From: Michael Eastham
Sent: 19 October 2017 08:05
To: 'Matthew Driver'
Cc: Paul Cann; Sue Howell; 'Stephen Gee'
Subject: BN/28/17/RES - Application for Reserved Matters - The Lillies, Yapton Road, Barnham

BN/28/17/RES - Application for the approval of Reserved Matters - The Lillies, Yapton Road, Barnham

JOB NO.	DRAWING NO.	REV
MATT151202	SL.01	P5

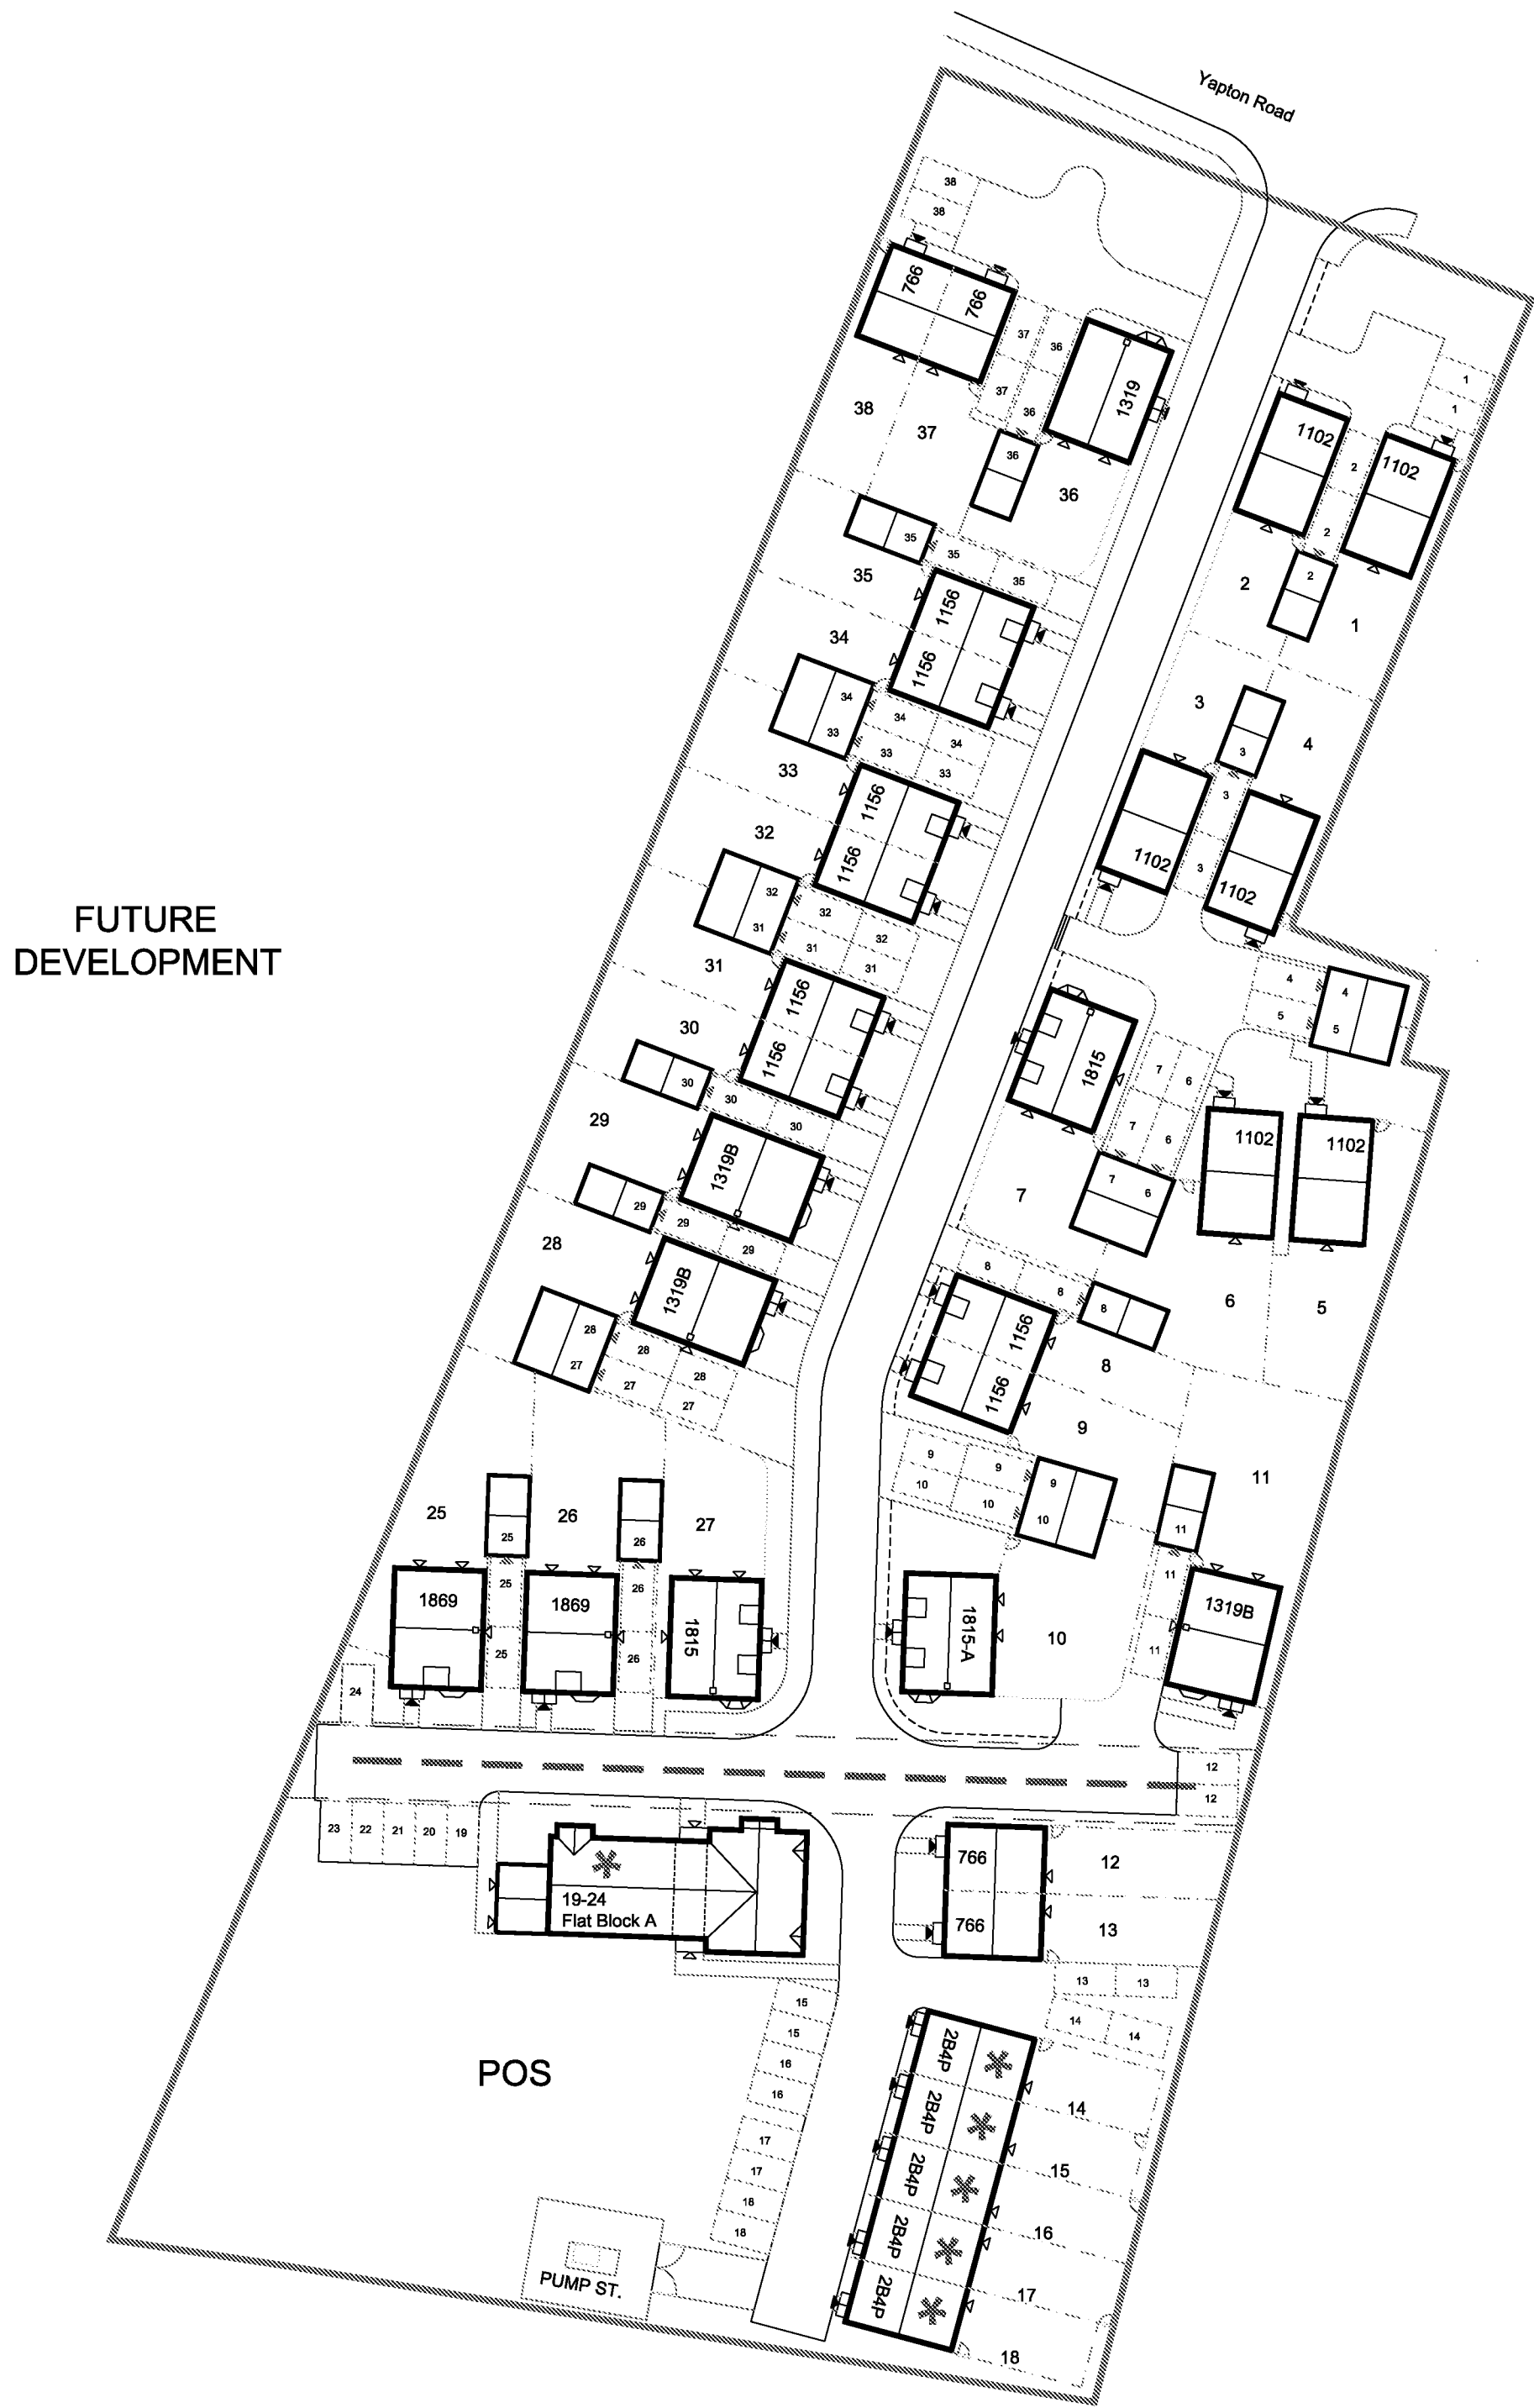
- 3) It was recommended at pre-application stage and again in an email sent by me on 16th August 2017 that the flatted building (the apartment block) be shown with some curtilage/defensible space particularly on the rear elevation which backs onto the POS. This has not been shown. The current arrangement would allow users of the POS to get right up to the ground floor windows.

- 4) It is also noted that no private space has been shown for the flats (the apartment block). Could balconies not be incorporated into the southern elevation of the building as well as the northern elevation?

- 5) Will you be submitting amended plans identifying usable public open space (POS) on the application site, and not just an area of land occupied by an attenuation pond, which is not usable POS?

APPENDIX D

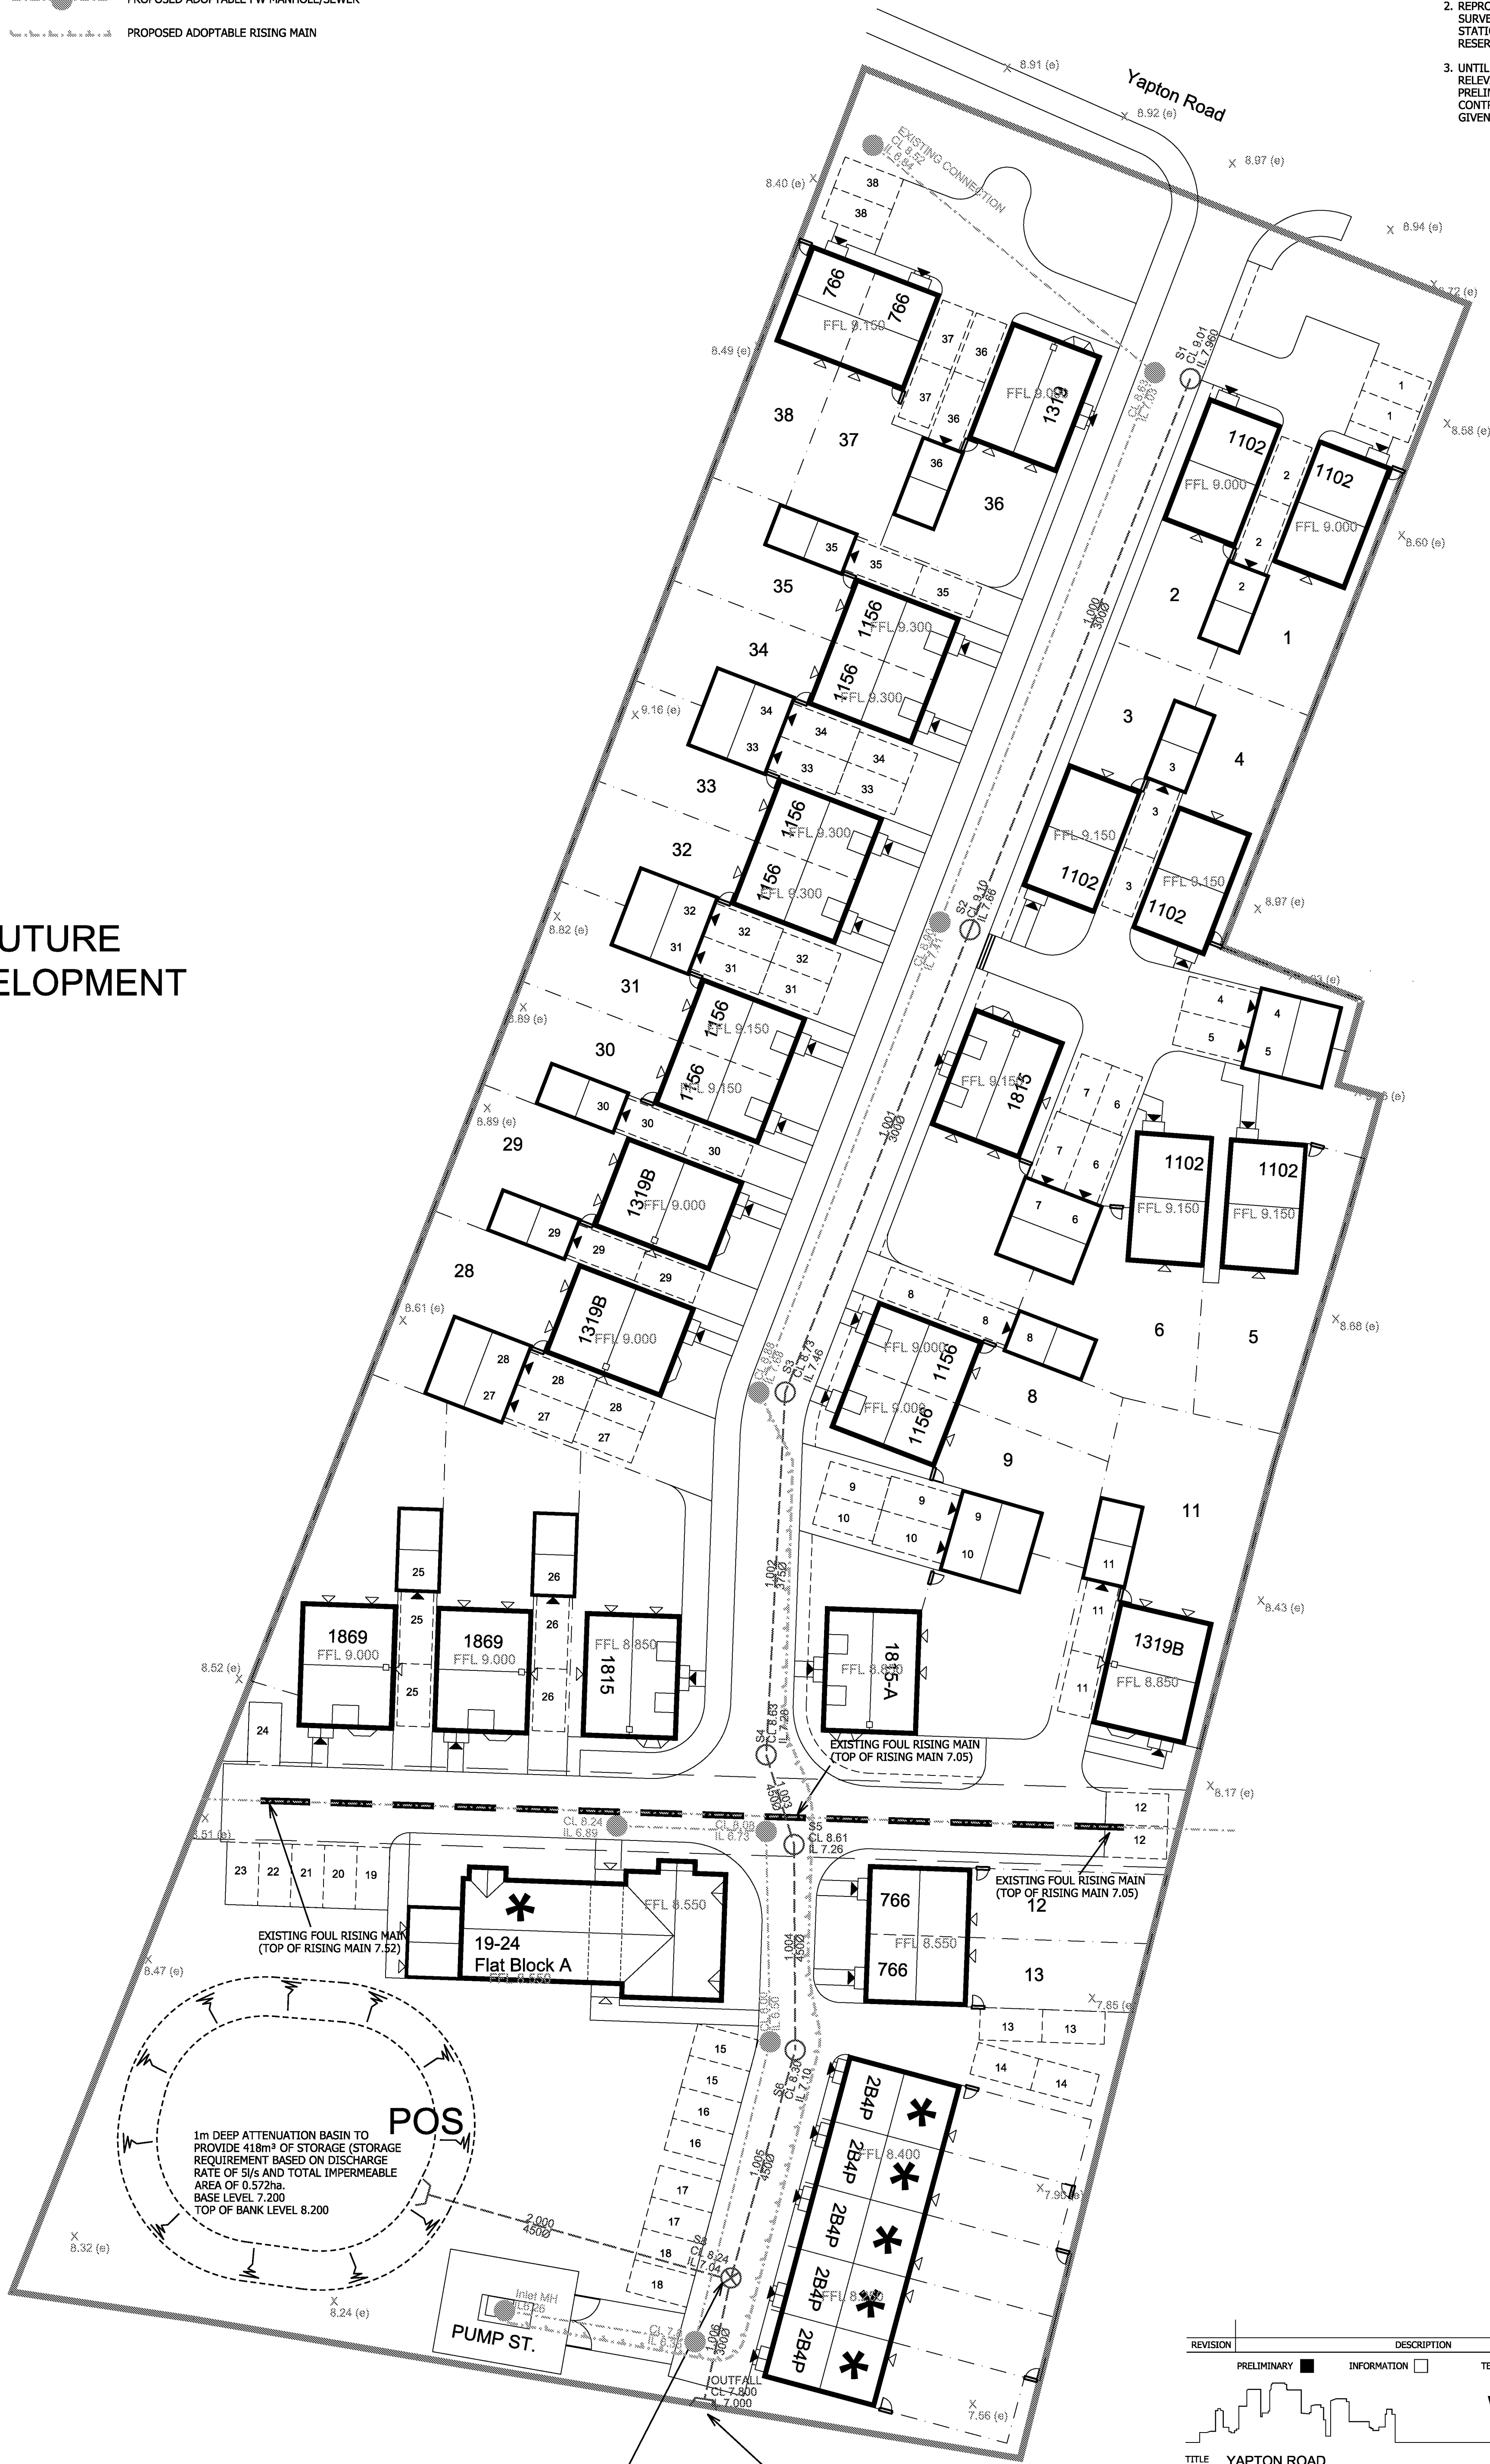
- 2) The requisite drainage details so that the ADC Drainage Engineer, Paul Cann, may sign off the drainage conditions which were imposed on the outline planning permission.
